Our Ref: P/40/22/NMA

**Section 96A of the Town & Country Planning Act 1990 (as amended)
Town and Country Planning (Development Management Procedure) (England) Order 2015
(as amended) - Article 10**

Non-material amendment following grant of P/70/19/RES to change some brick types on the Materials Schedule to some of the dwelling plots (Plots 51-52, 86-87 and 88-89) and replace rooflights to some plots to dormer windows (Plots 51-52, 86-87 and 88-89).

Land To The West Of Pagham Road Pagham PO21 4NG

S1  
EO-F-06  
EO-G-05

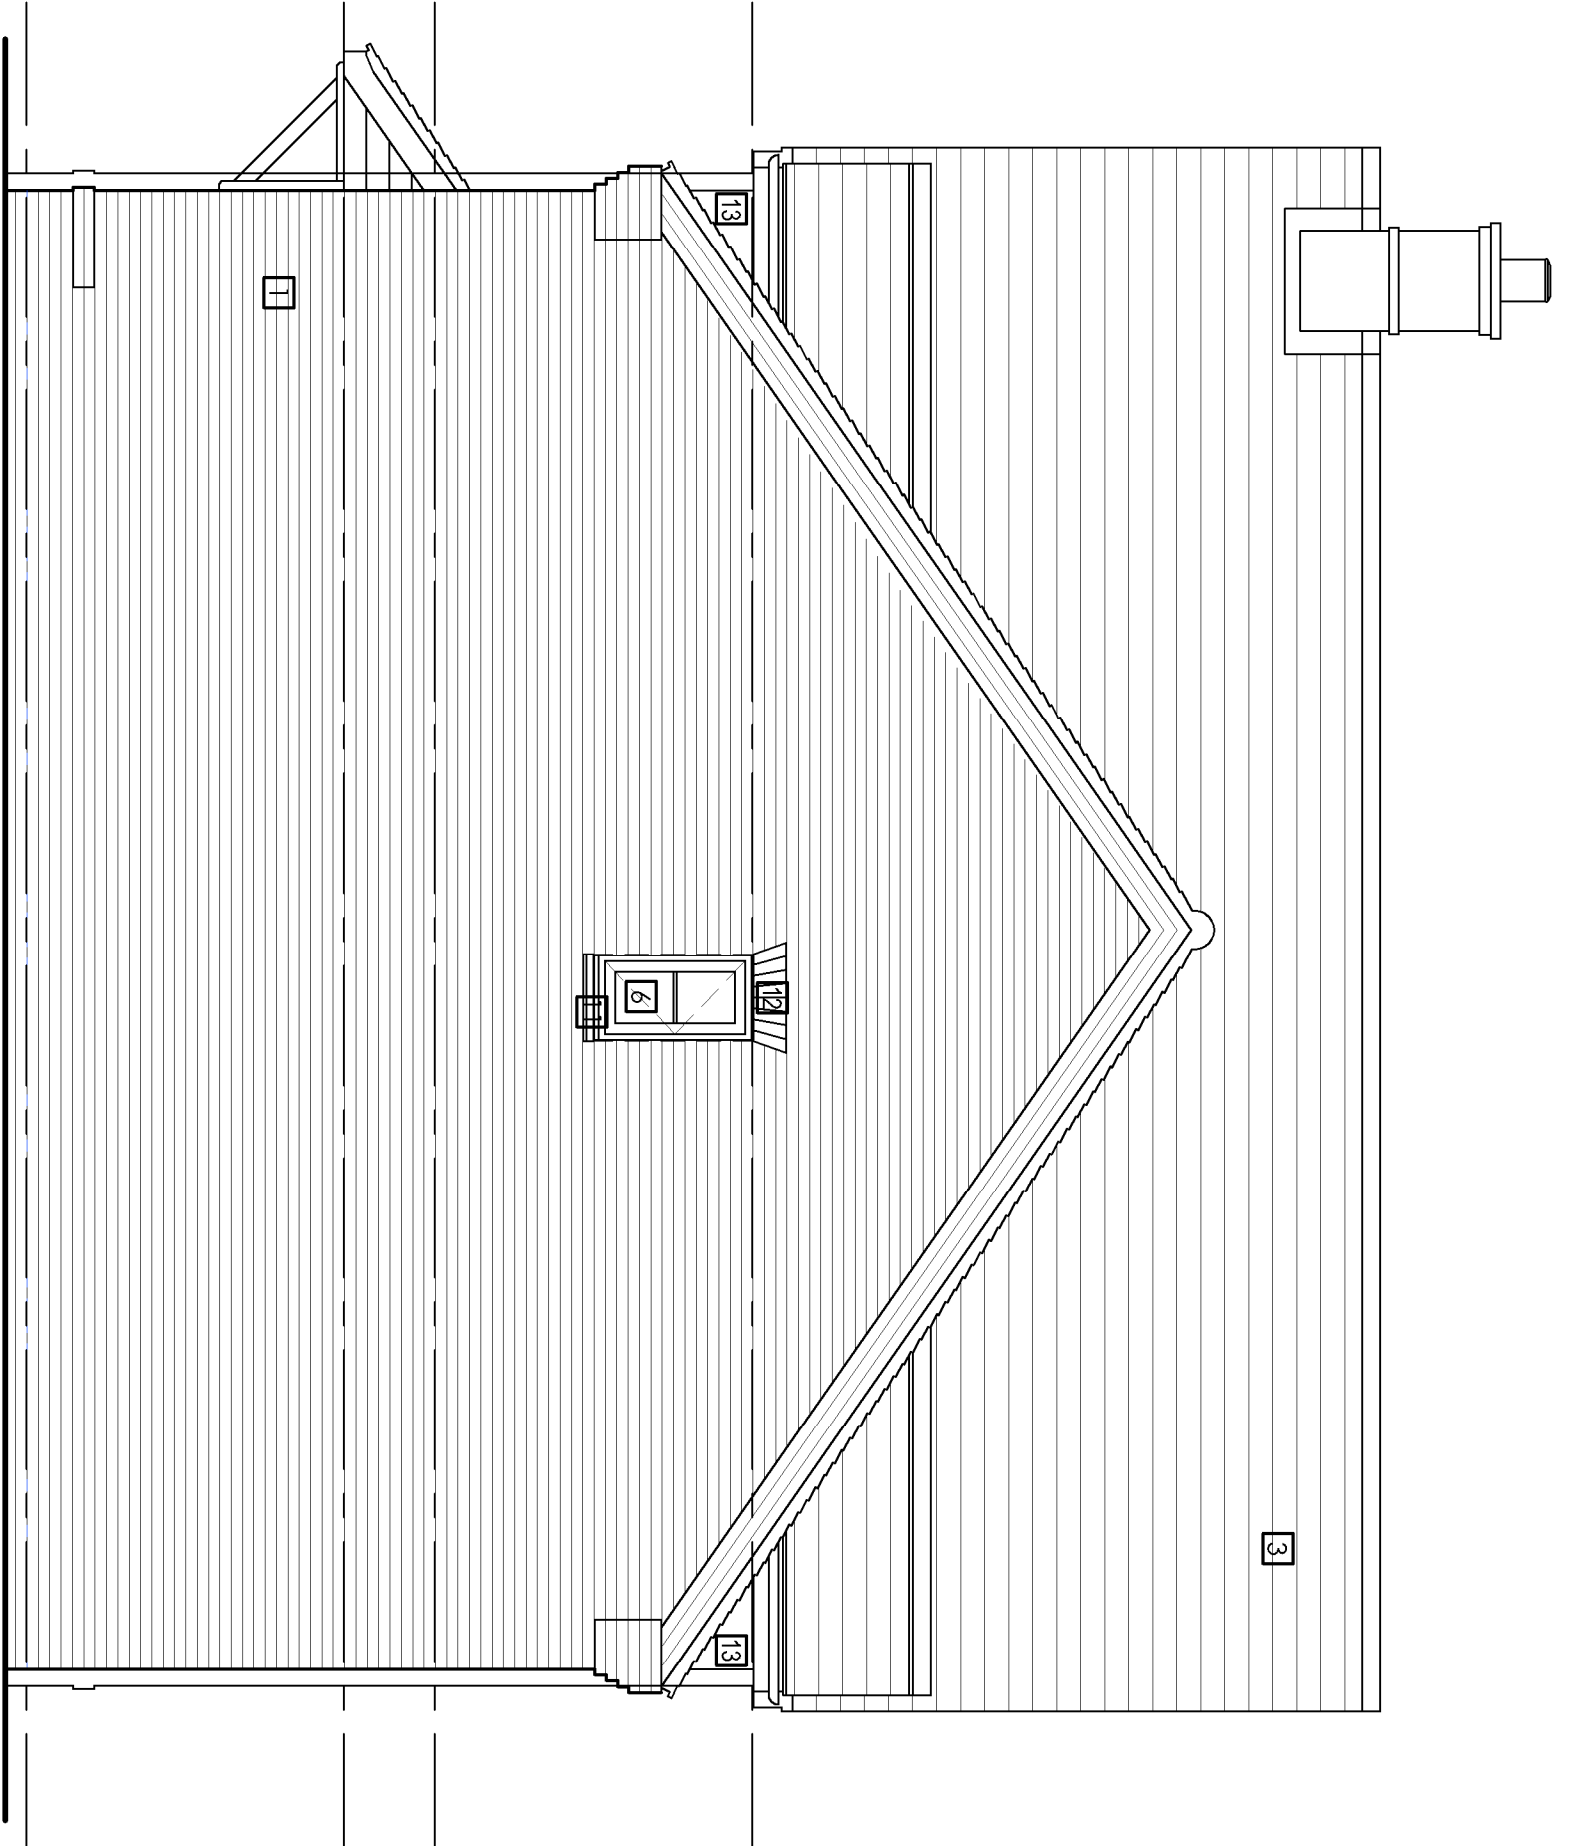
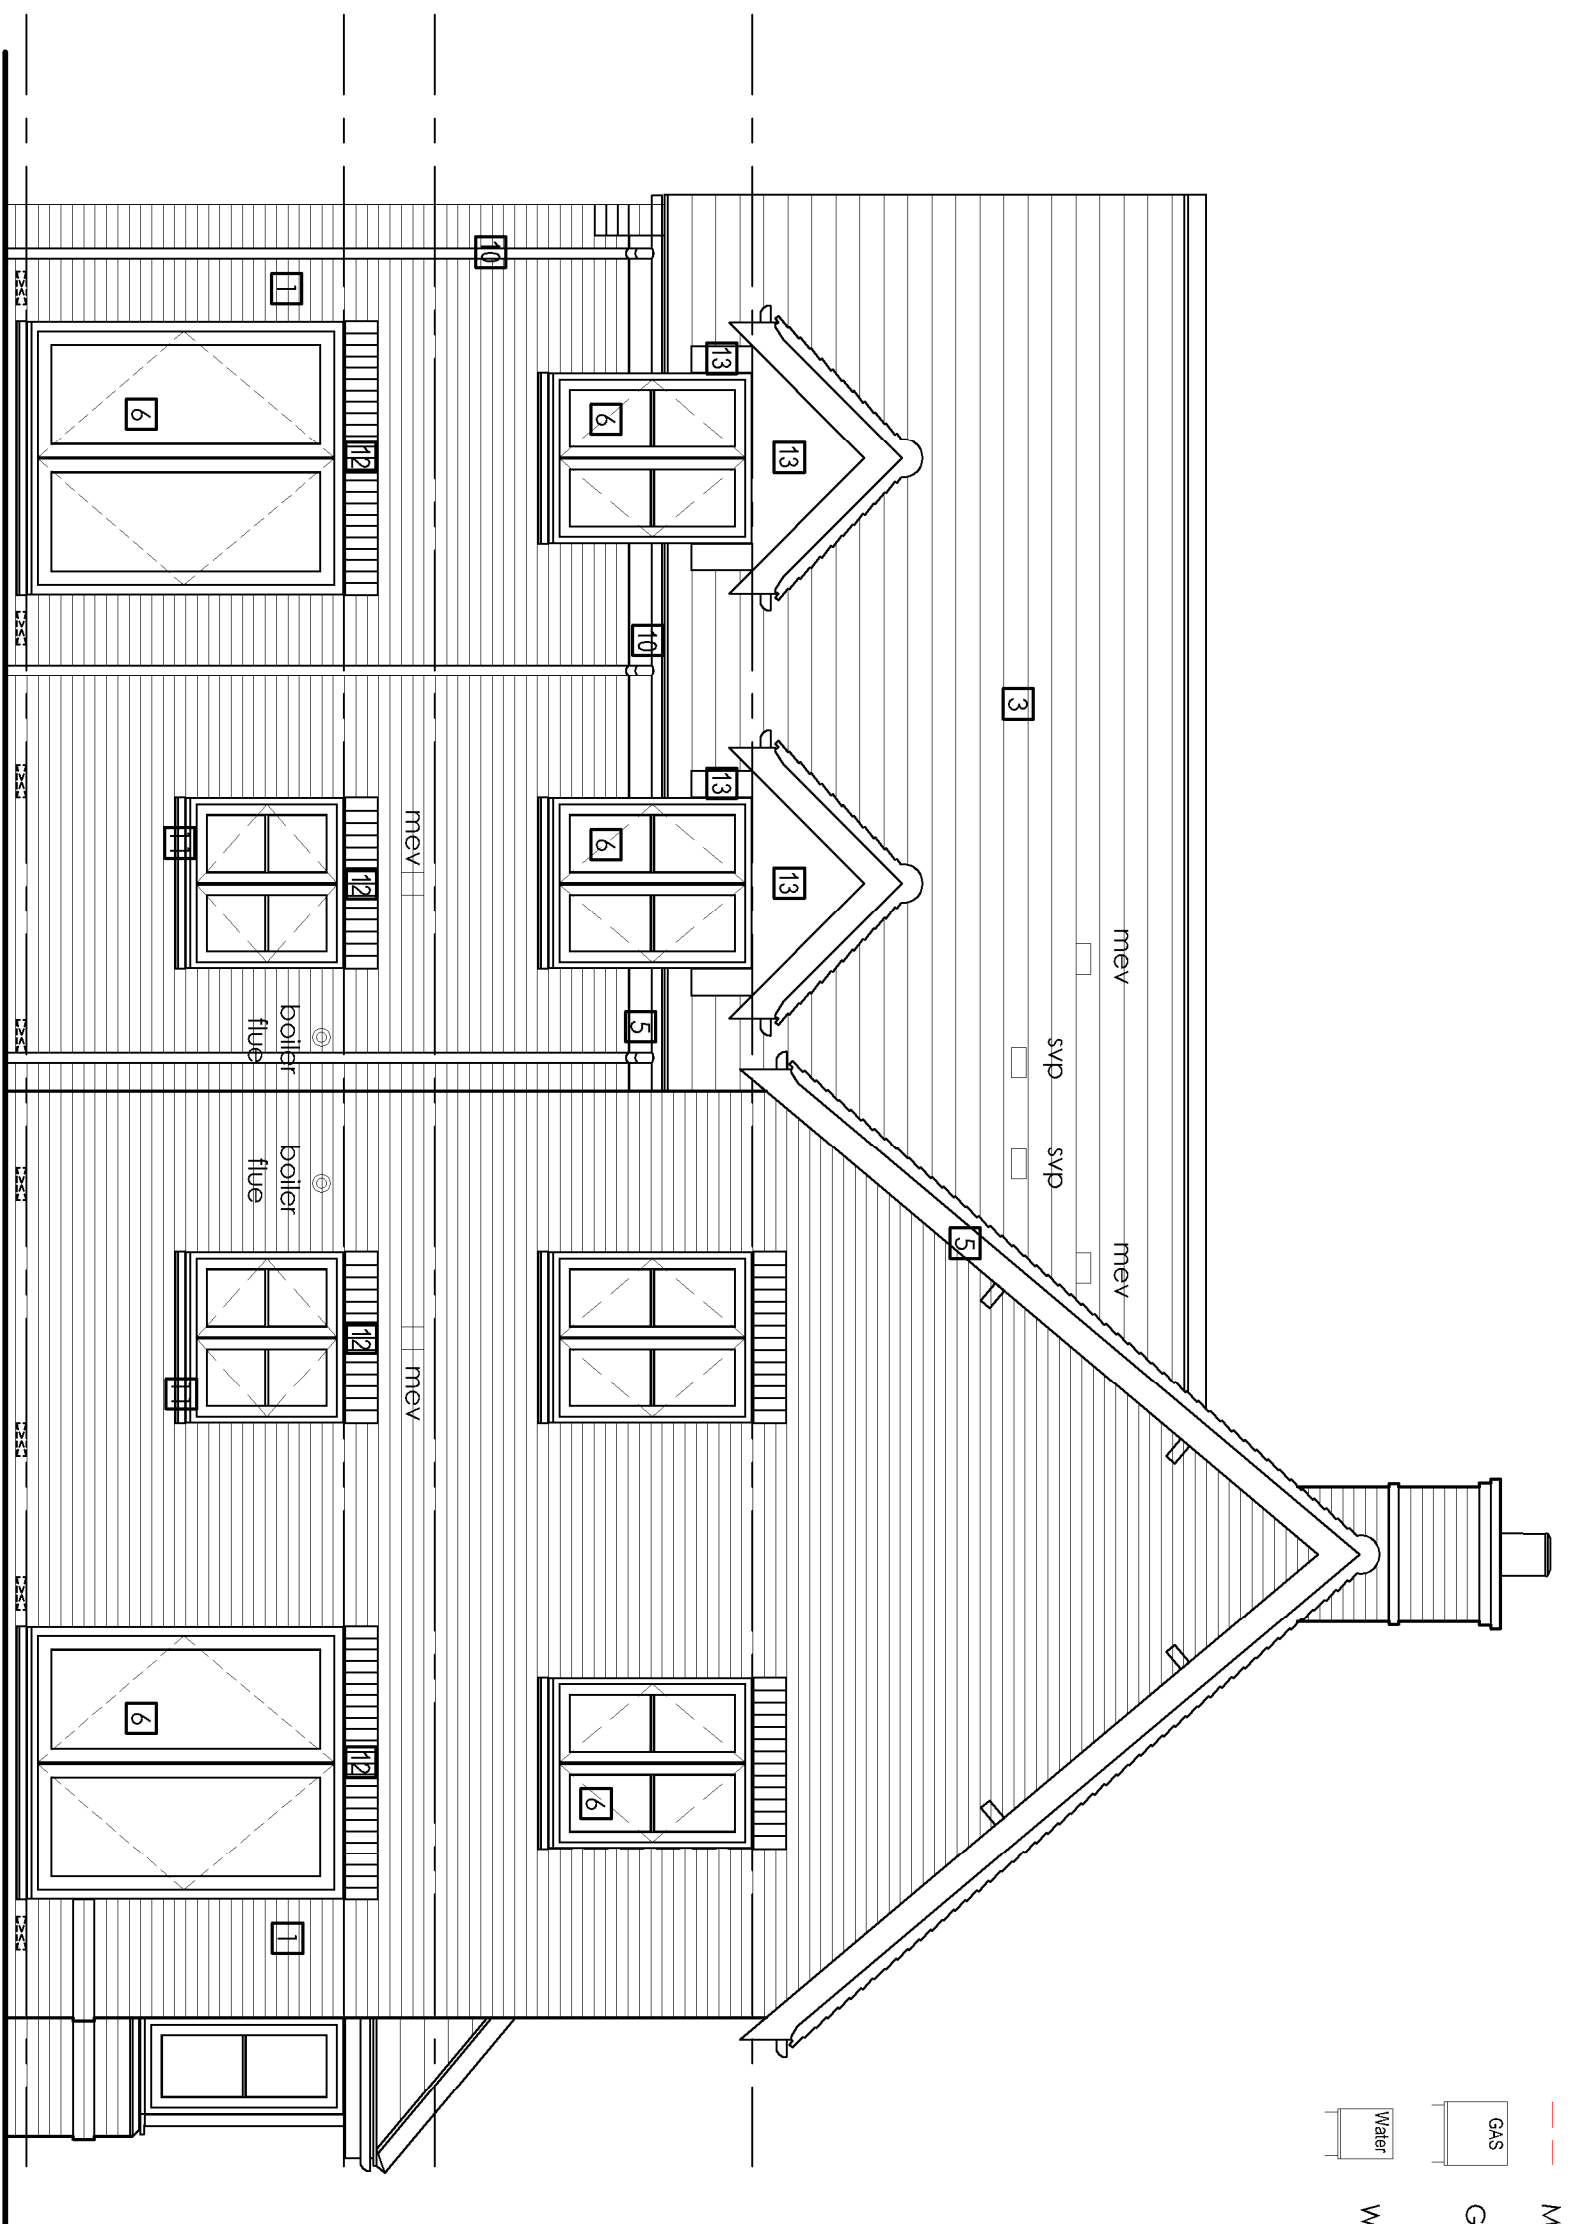
- use Ibstock Thakeham Red Multi Stock to some of the plots;
- use Vandersanden Sundridge Handmade Stock instead to some of the plots;
- replace roof lights on the fronts of the Hickstead house type (plots 51-52 & 86-89 only) with small dormers to match those already on the front and rear elevations.
